BR/194/21/HH

21 West Street Bognor Regis PO21 1XA

Erection of first floor home office above existing outbuilding. This application may affect the character and appearance of The Steyne, Bognor Conservation area. This application may affect the setting of a Listed Building.

Drawing Title
EXISTING +
PROPOSED DETAILS

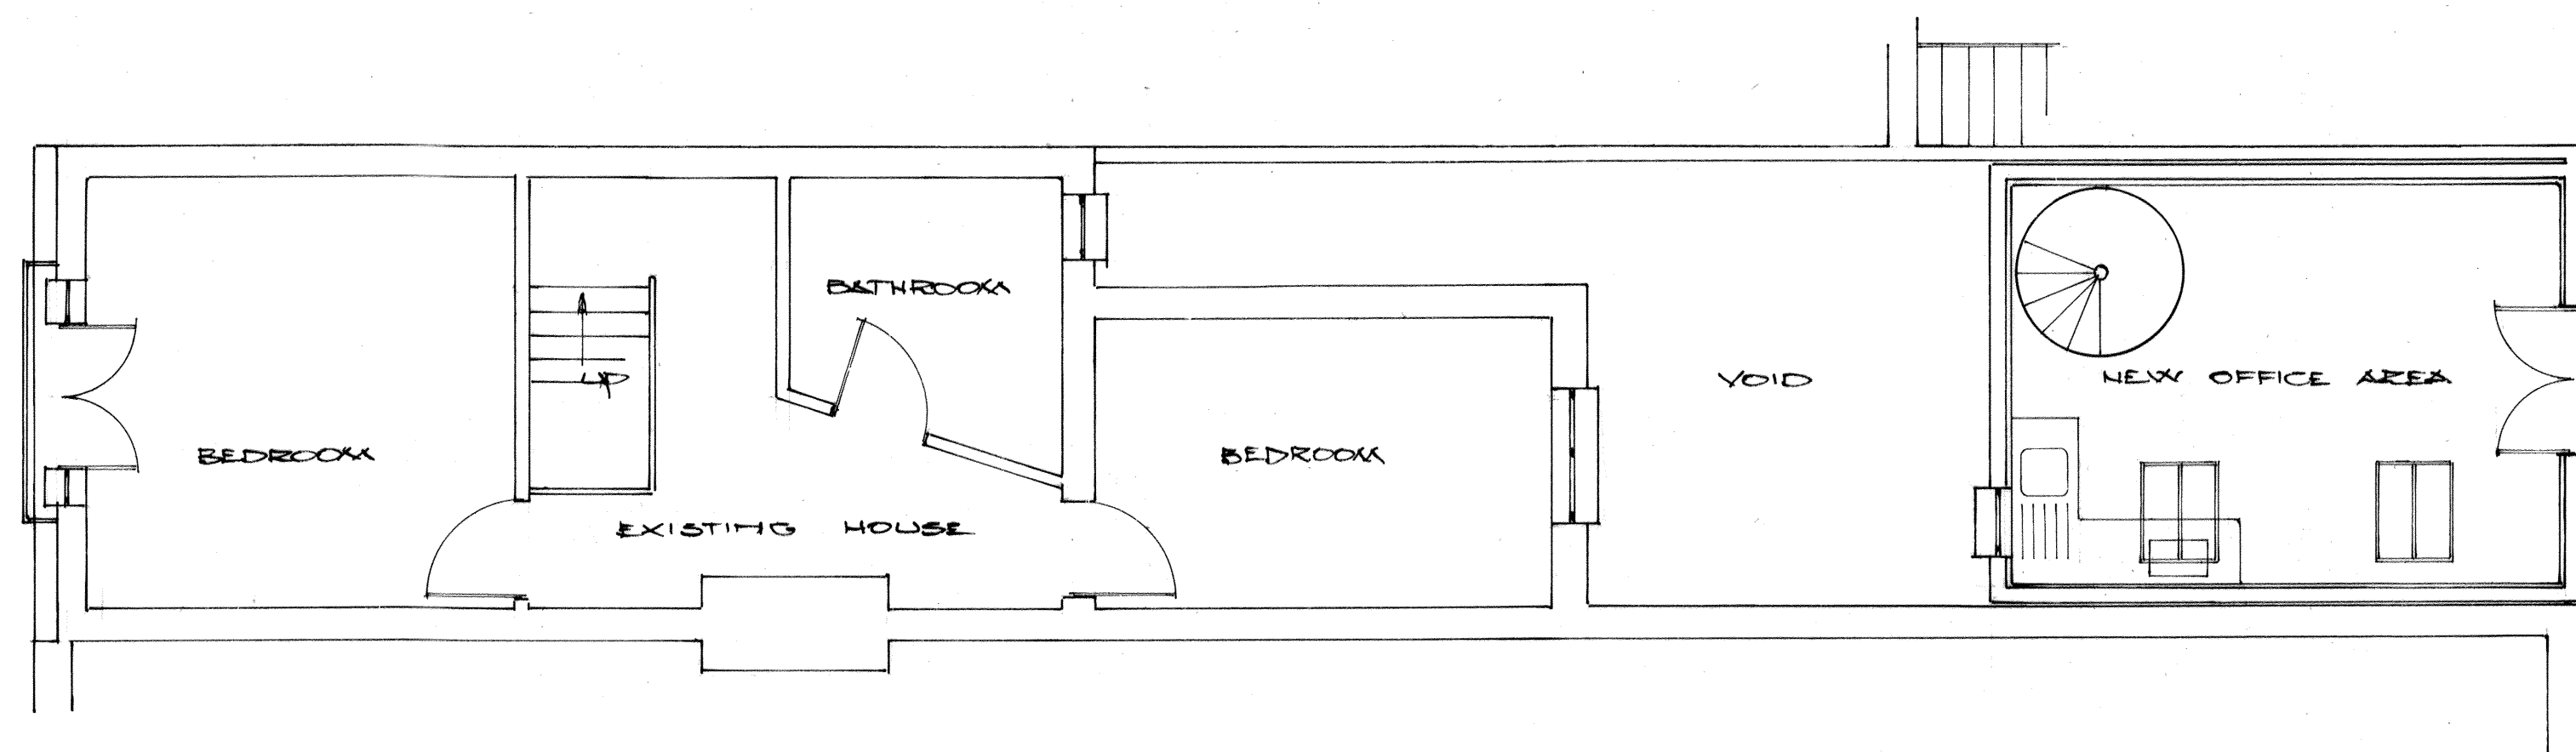
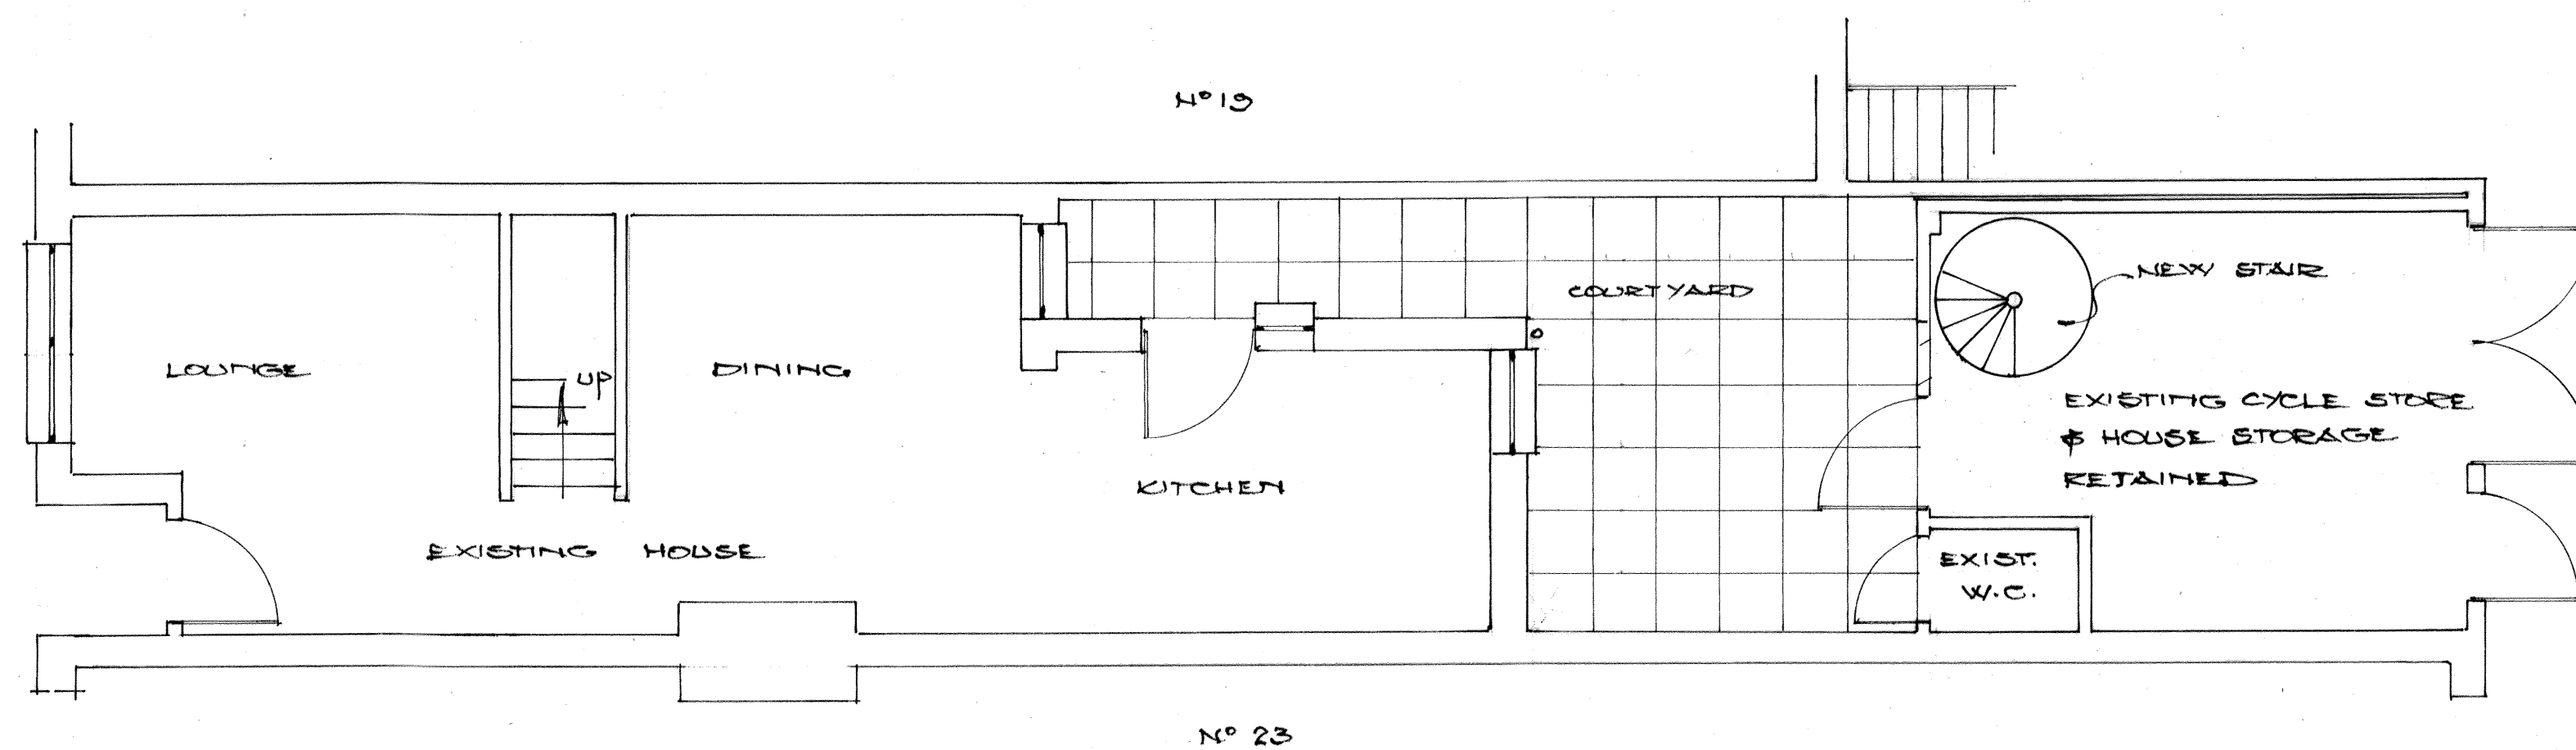
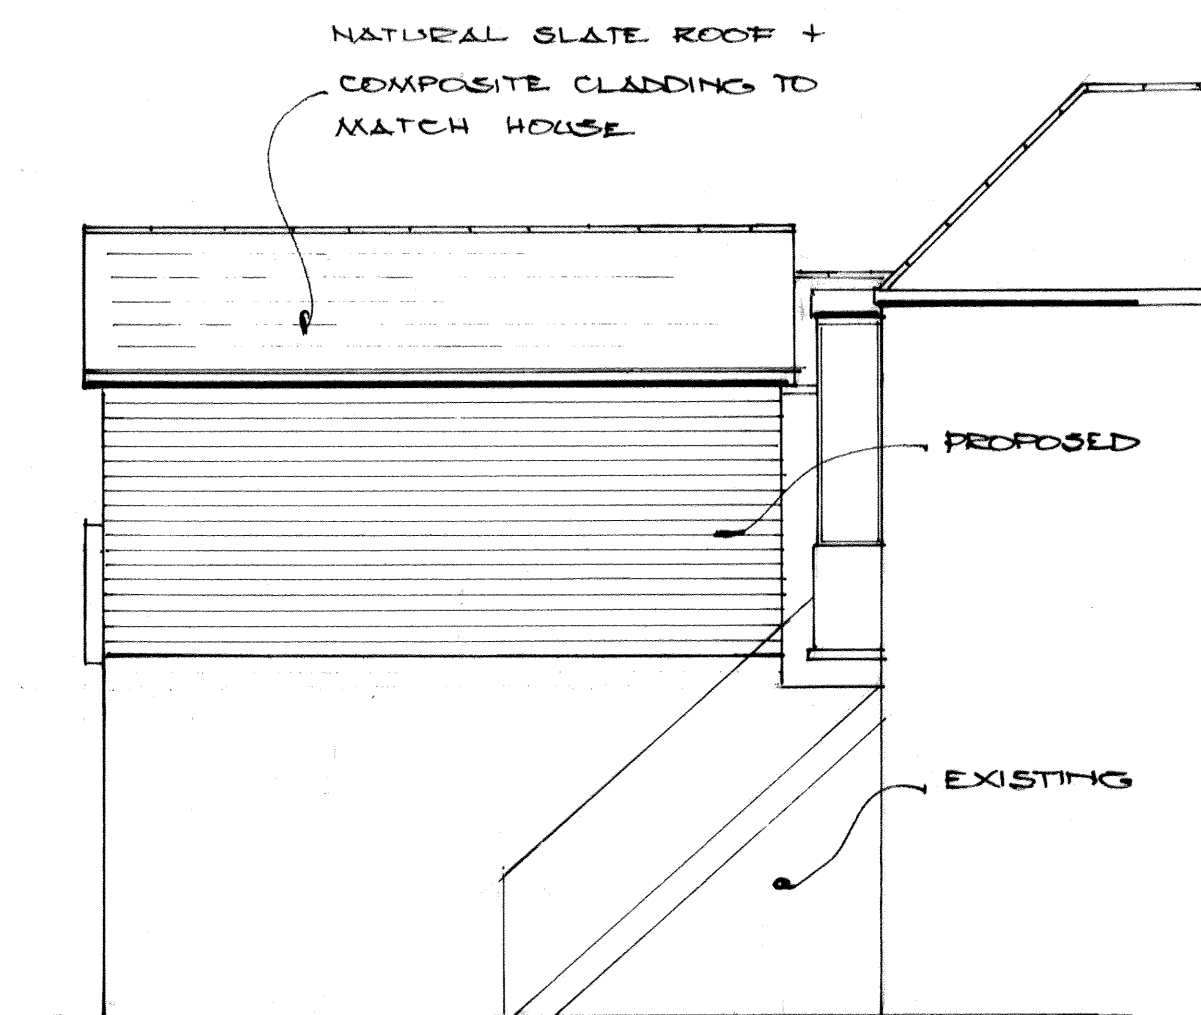
It would appear that the intention is for the windows and French windows to be UPVC. UPVC is not a traditional, vernacular material and is unsuitable for use in historic buildings. Such windows are often crudely detailed, and the size of frame is usually much larger than that of a traditional window, giving them an obtrusive, 'chunky' appearance. The 'shiny' finish of uPVC is also out of keeping with traditional materials. The use is therefore not appropriate for a conservation area.

Whilst the intention to improve the building and hopefully encourage other residents to improve their own is positive, there are some concerns regarding the use of materials, which are not appropriate for the conservation area. Therefore, unfortunately, at the present time I am of the opinion that the proposal is such that the impact can be described as causing less than substantial harm in accordance with paragraph 202 of the NPPF (2021). The level of harm is considered to be on the lower end of the scale. As such, you will also need to consider the public benefits that the development may achieve as part of your assessment of the application, along with the contents of the Planning (Listed Buildings and Conservation Areas) Act 1990 (as amended).
